The Secretary
NSW Department of Planning and Environment

19 October 2022

I refer to the Department's email of 14 October 2022 regarding the Modification Application and Report for State Significant Development SSD-10448-Mod-3 Aspect Industrial Estate for 'Reconfiguration of the Estate layout south of Access Road 1 and west of Access Road 3 resulting in a reduction from 6 to 4 lots and new warehouse footprints and associated amendment to Access Road 4' at 804-882 Mamre Road, Kemps Creek, NSW 2178 (Lots 1- 5 DP 1285305) in the Penrith City Council Local Government Area (LGA). Submissions need to be made to the Department by 14 November 2022.

SSDA-MOD 3
ESTATE MASTERPLAN
DATE: 28.07.22 SCALE: 1:4000 @ A3 21/250 MP5-02 A

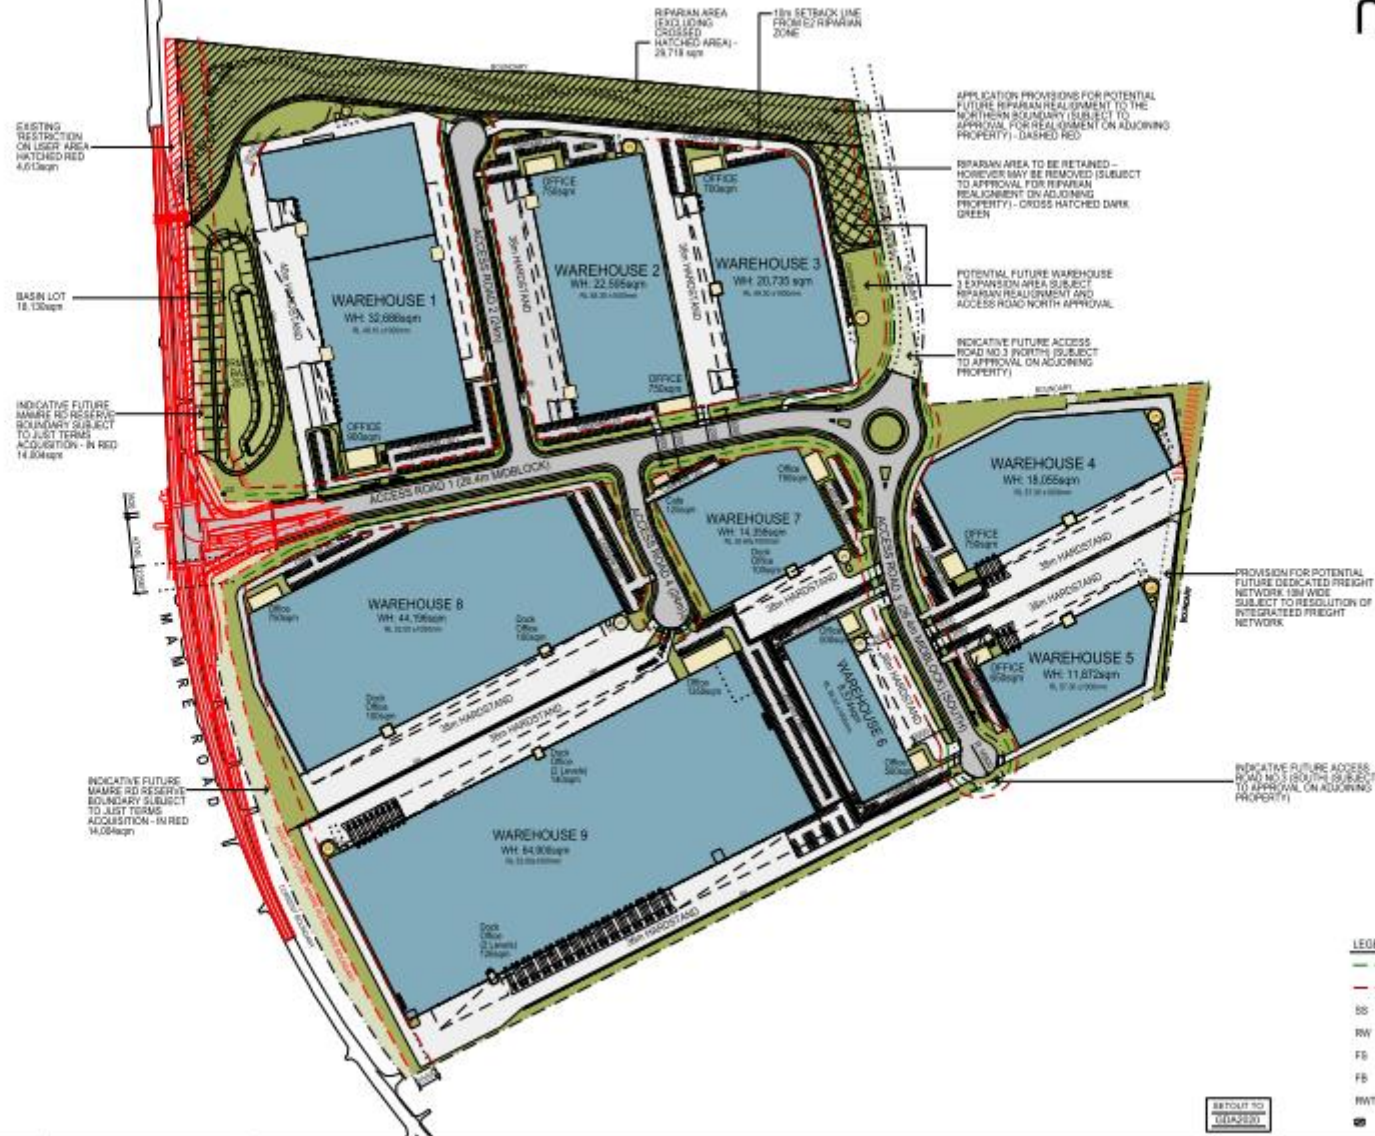
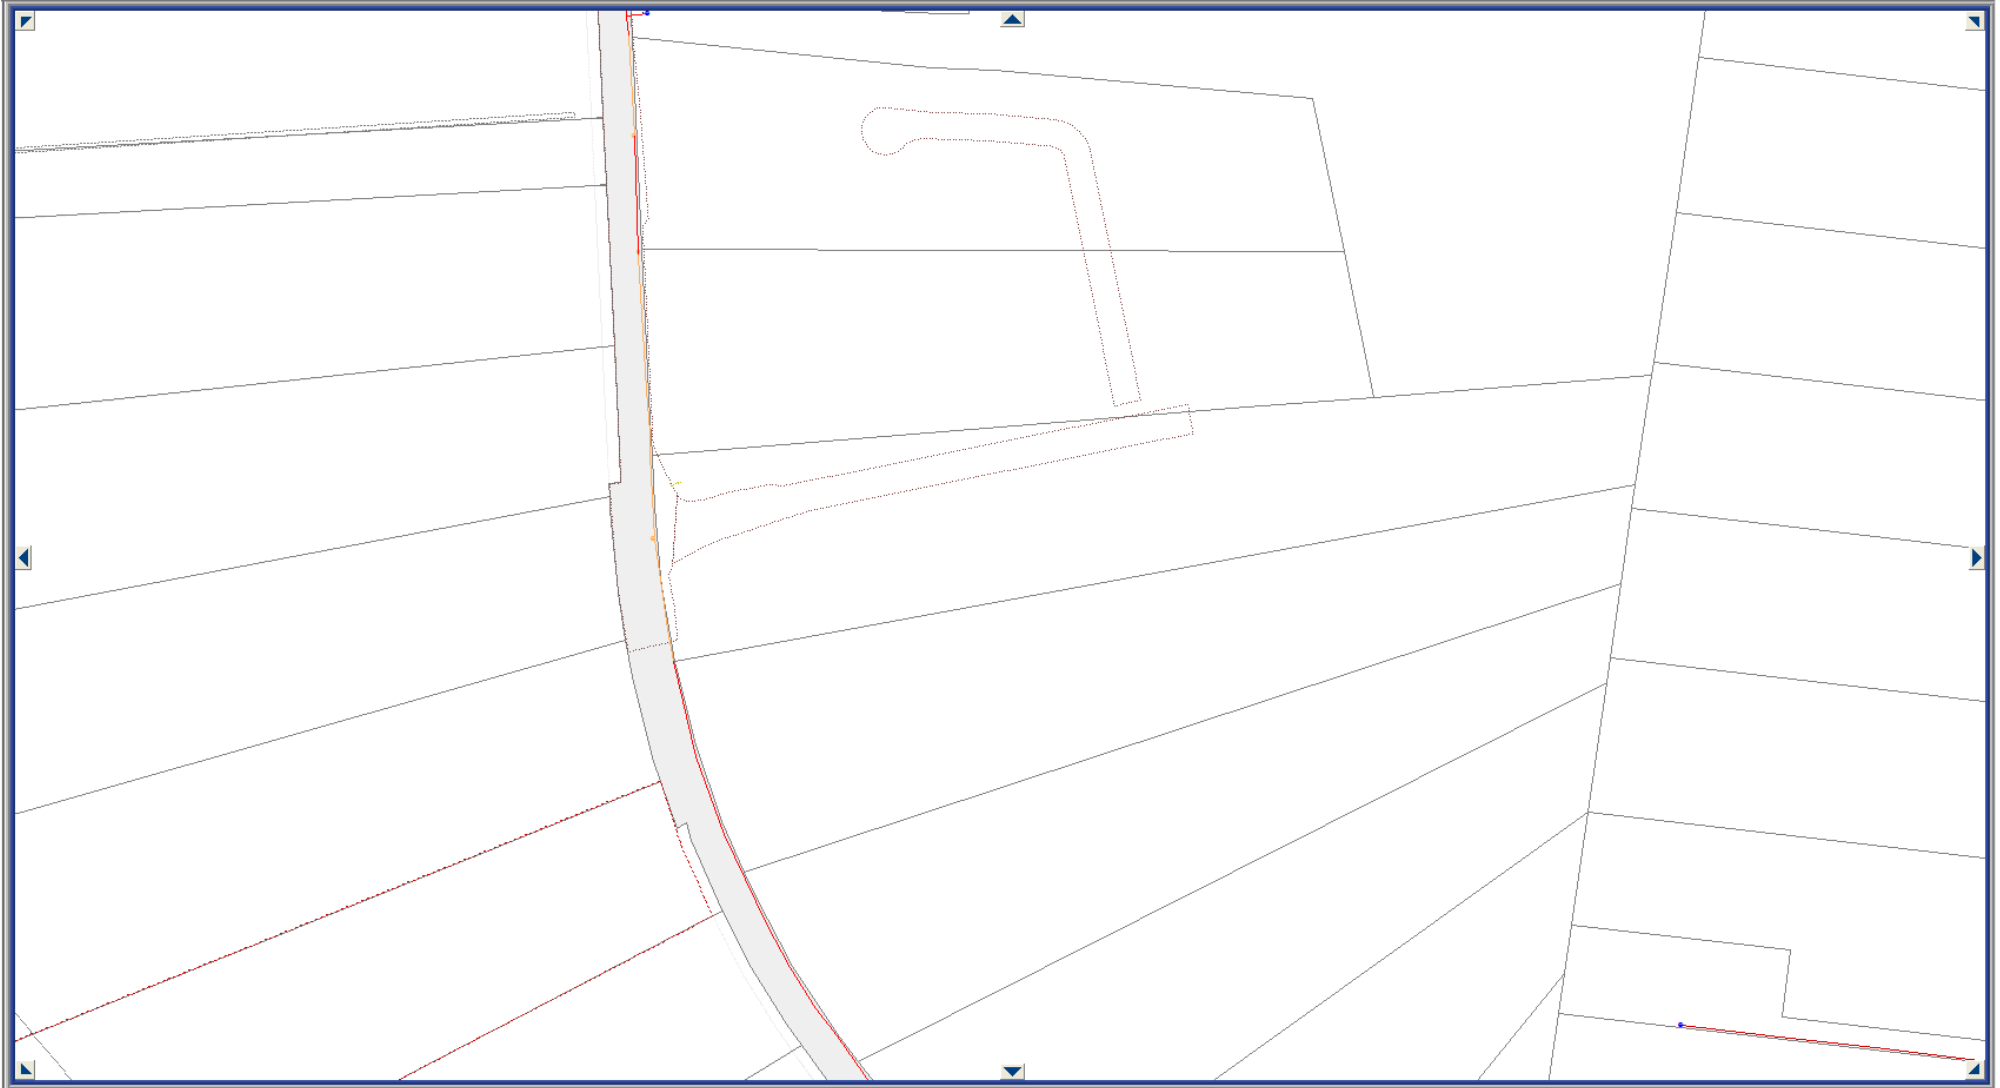
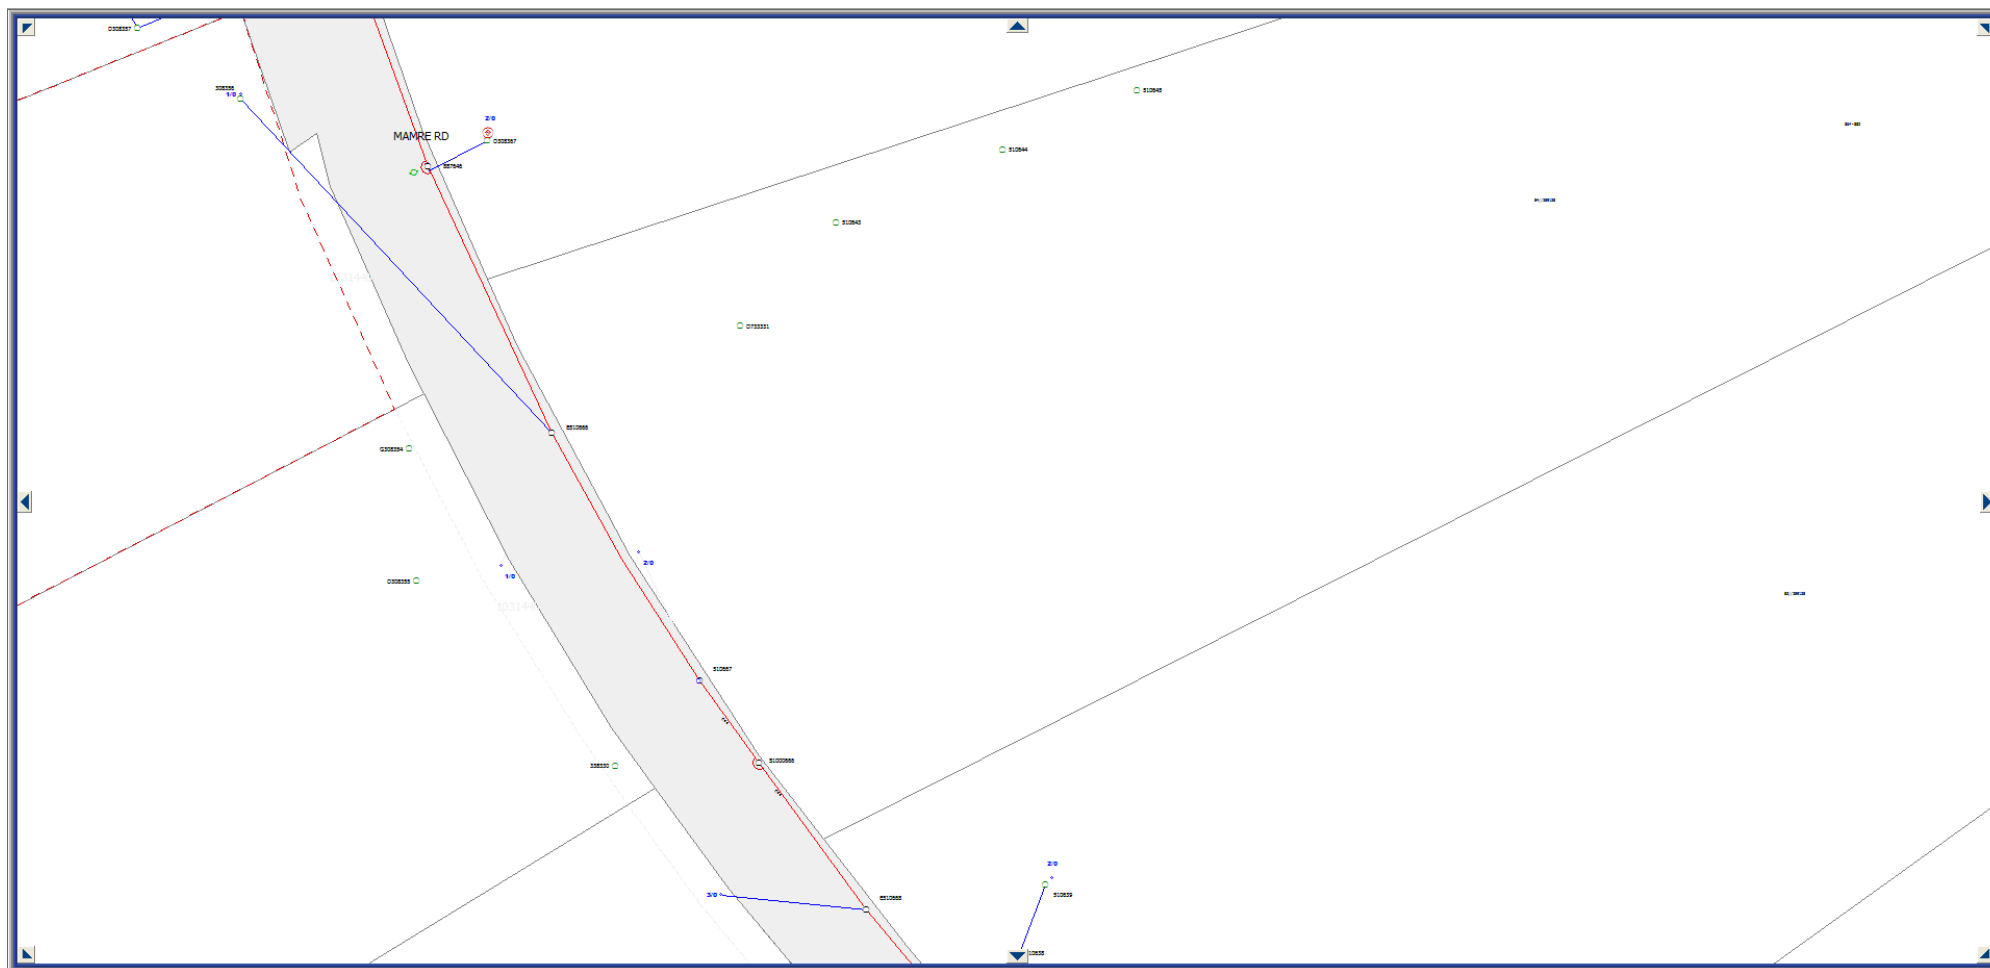
It is apparent that the road layout shown in the Estate Masterplan does not correspond to that shown in the Site Plan from Endeavour Energy's G/Net Master Facility Model.
